PM-21-00003

**PREAPPLICATION CONFERENCE APPLICATION  
& MEETING SUMMARY**

11. Proposed Project Name: The Bull Ranch

**Subject:** The Bull Ranch Pre- Application Meeting, CDS Planning Notes

A PORTION OF SECTION 12 T. 17 N., R. 18 E., W.M., KITTITAS COUNTY, WASHINGTON

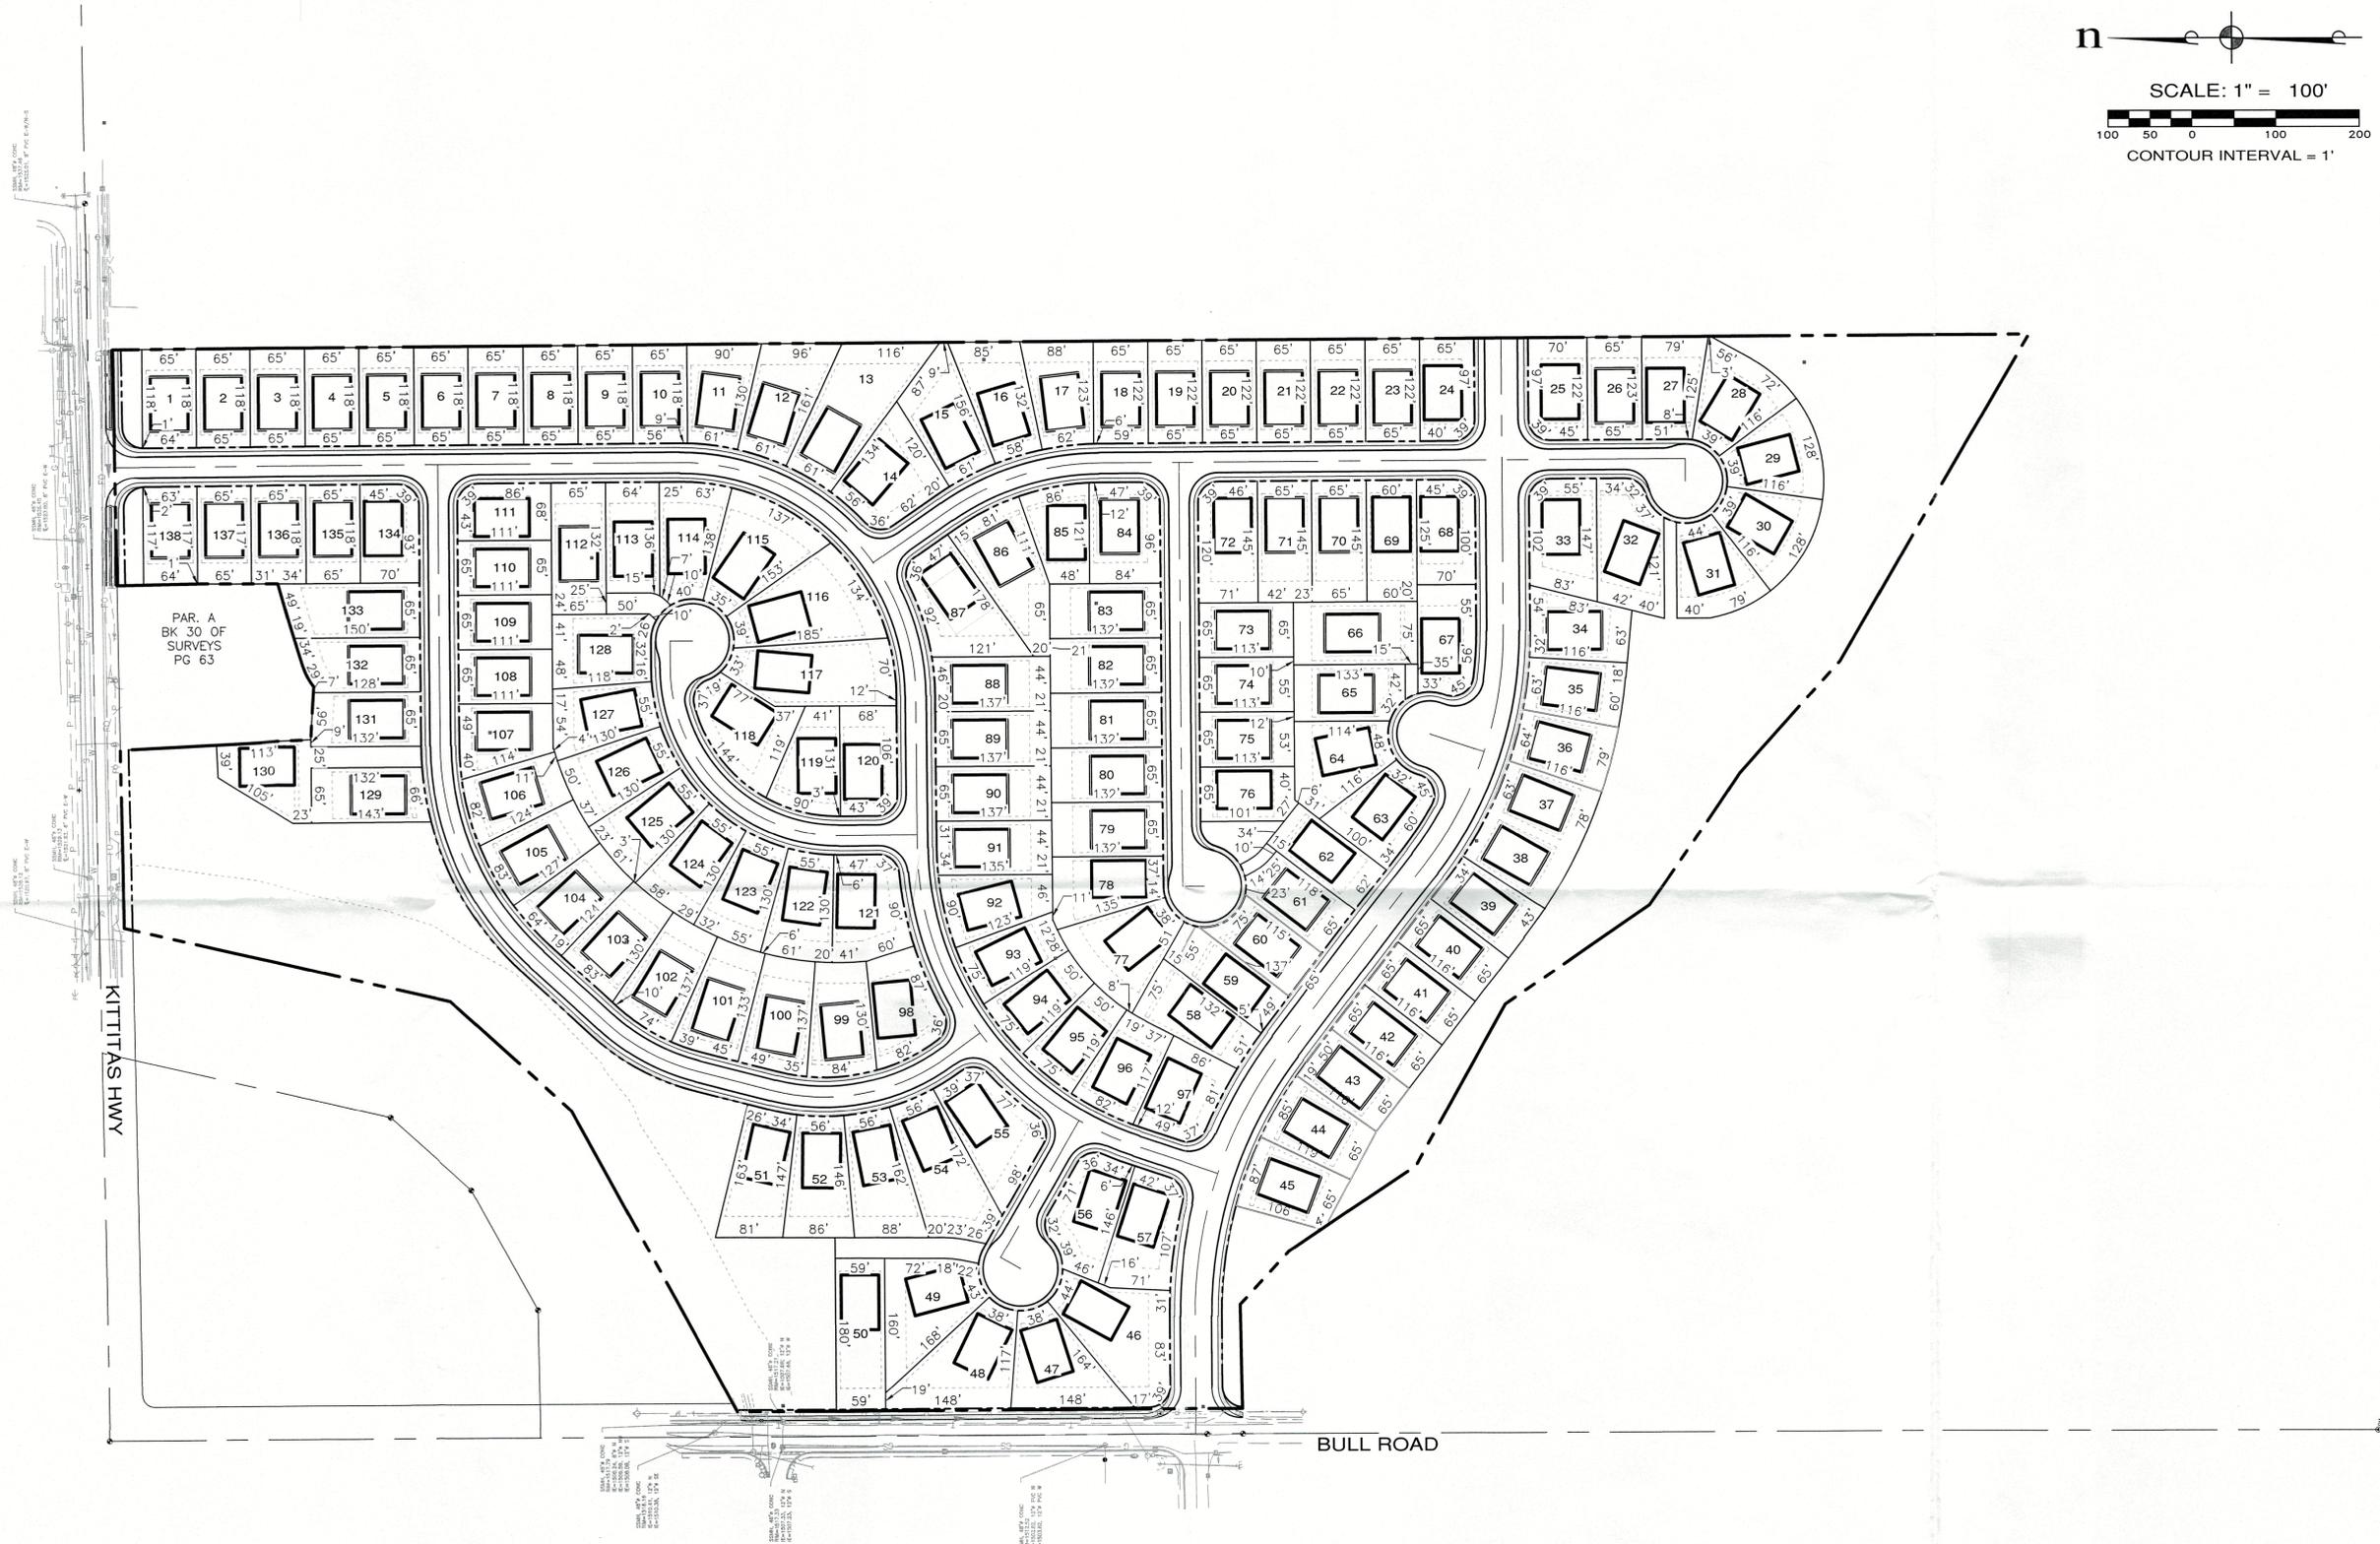
A Type 9 (unknown) stream appears to border much of the western border of the parcel. Depending on the nature of this stream, structural setbacks could be required.

Lyle creek meanders through this site on the western property boundary and has a 50 foot stream buffer which will need to be considered.
